**Consultation Response from KC,
Highways Development Management**

2023/92034 adj, 655, Halifax Road, Hightown, Liversedge, WF15 8HE

Discharge condition 4 (parking), 6 (materials), 8 (Phase I Desk Study Report), 9 and 10 Phase II Intrusive Site Investigation Report, 13 (charging electric vehicles), 16 (drainage) on previous permission 2019/93380 for erection of detached dwelling with associated parking and amenity space

Date Responded: 2-10-2023.

**APPENDIX 2**

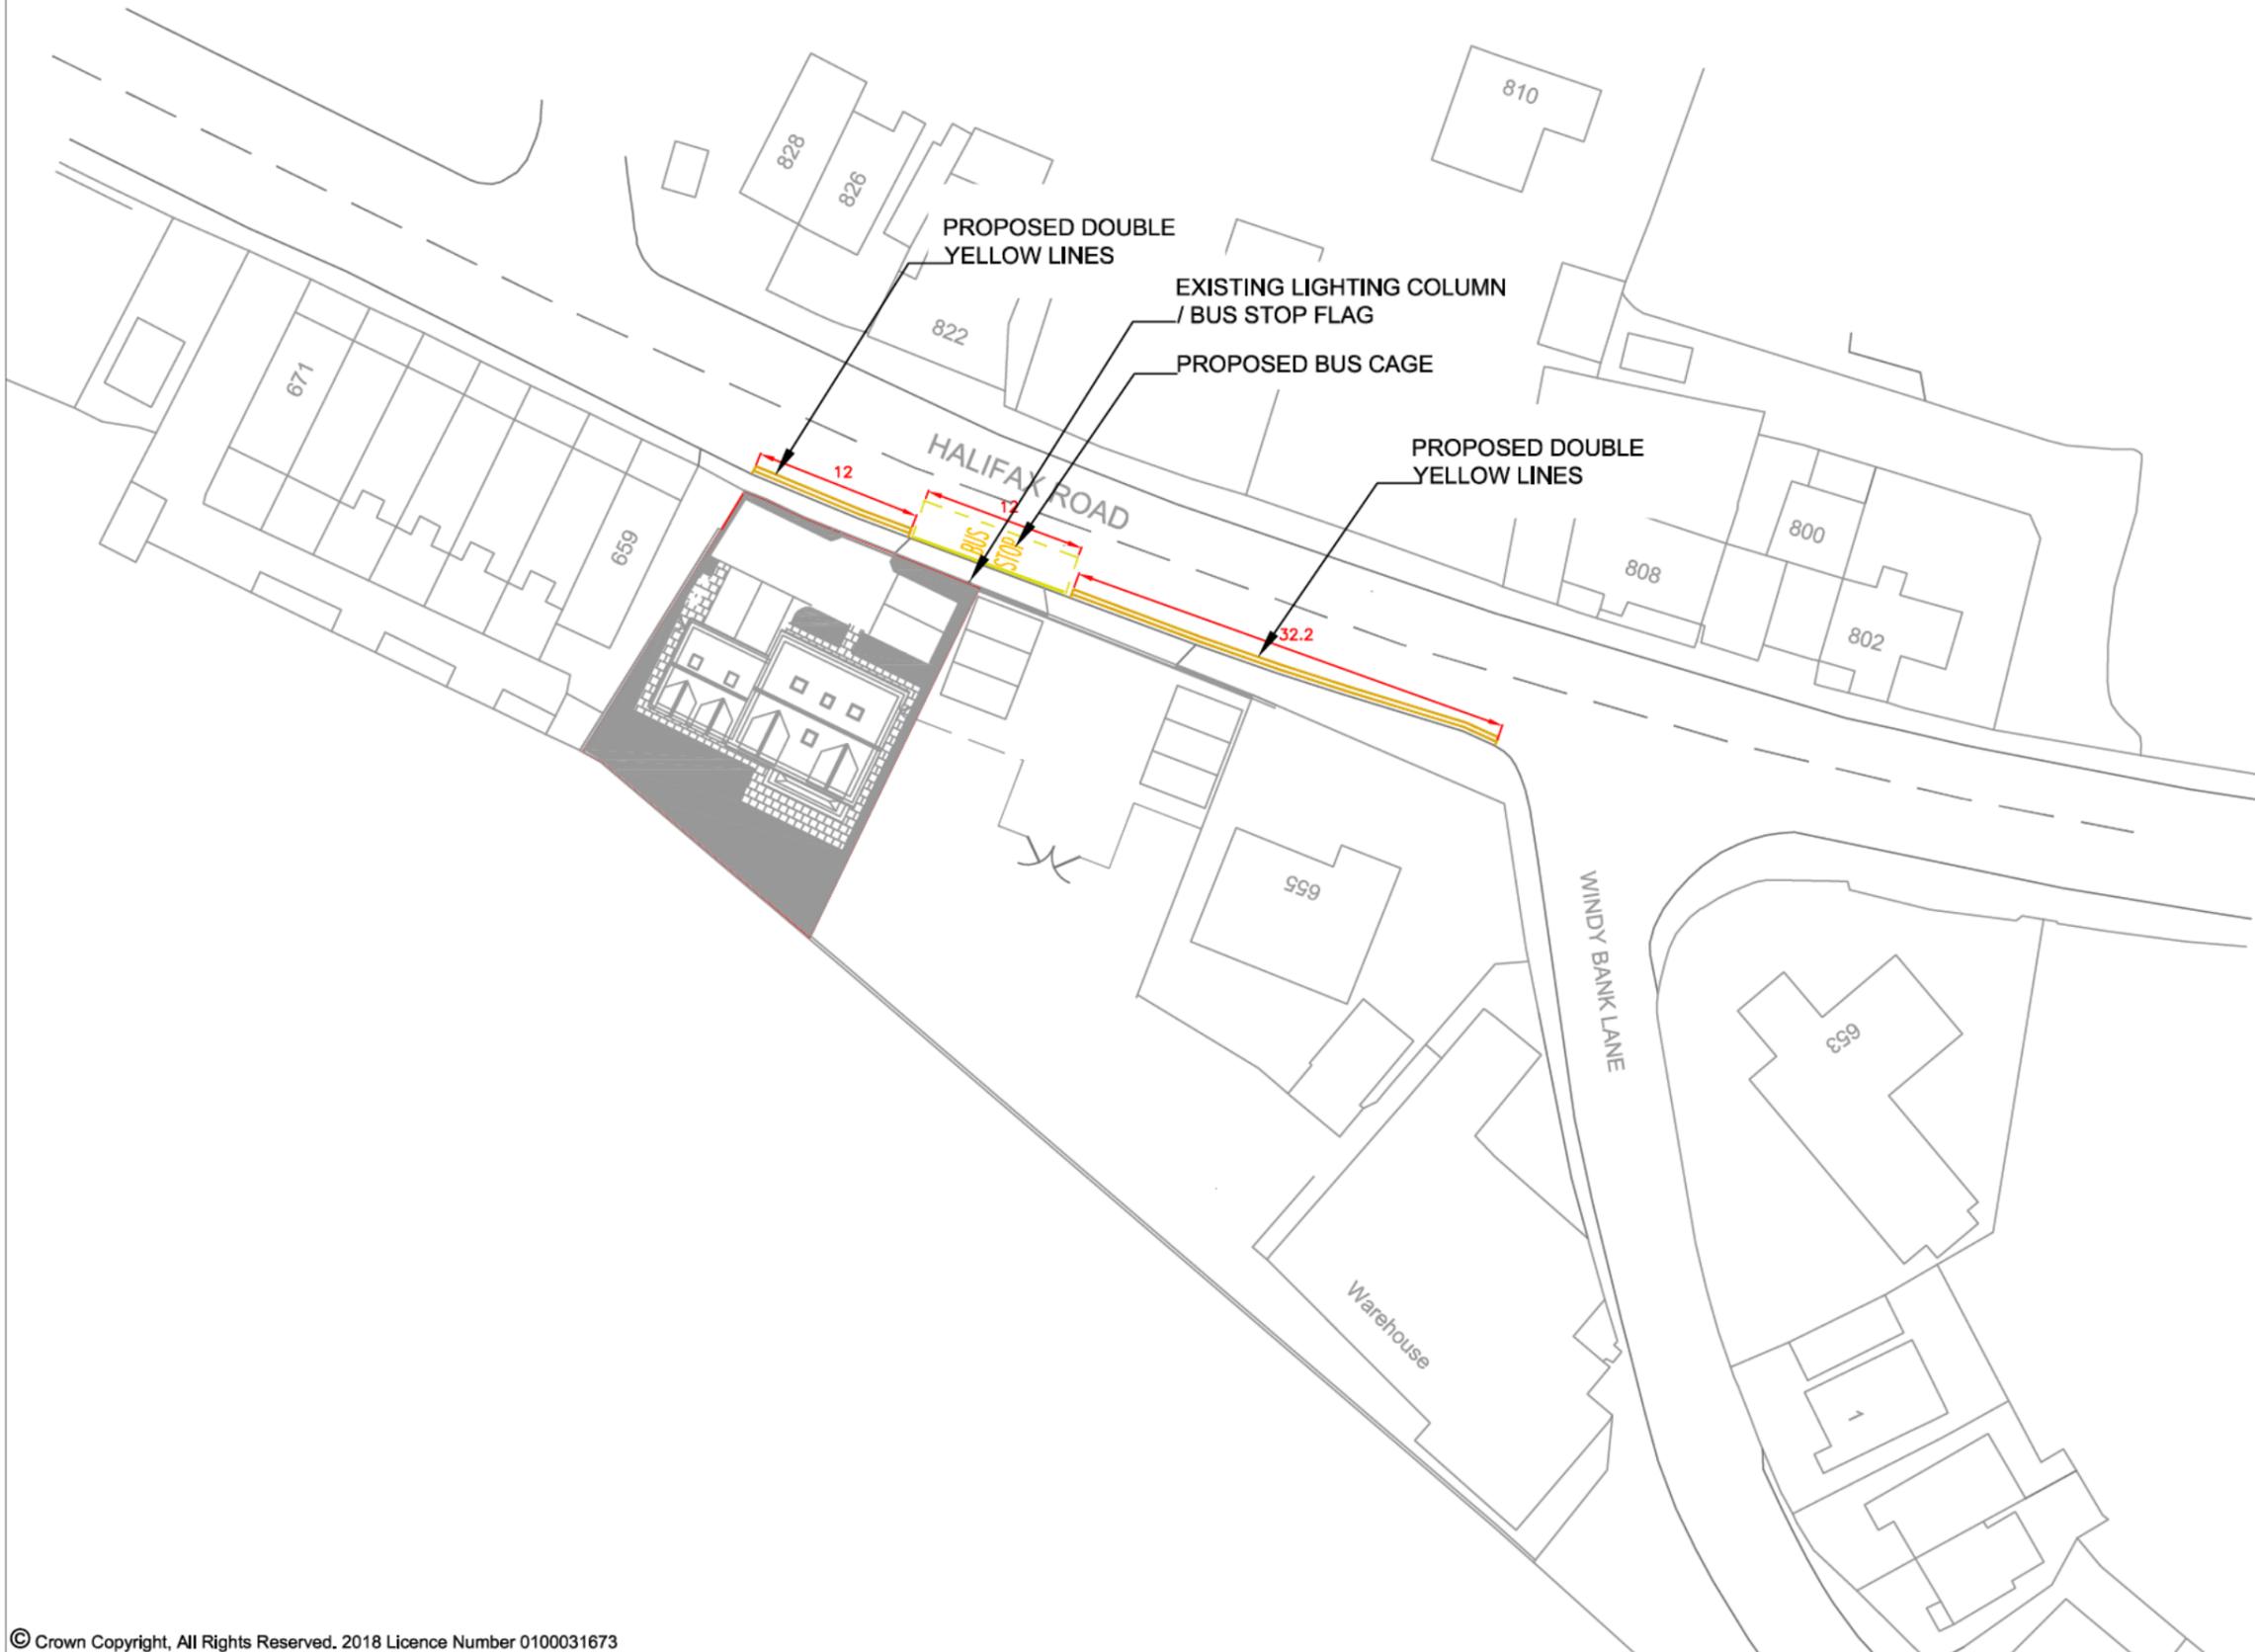
The proposals for double yellow lines and bus stop markings along Halifax Road between the site access and the junction with Windy Bank Lane are shown within appendix 2 of the technical note prepared from SCP, Plan number SCP/190932/SK03 rev A (Proposed double yellow lines).

These proposals are considered sufficient to satisfy the first part of this condition “*a scheme detailing measures to manage parking on Halifax Road between the site access and Windy Bank Lane and all associated works, together with appropriate Safety Audits*”.
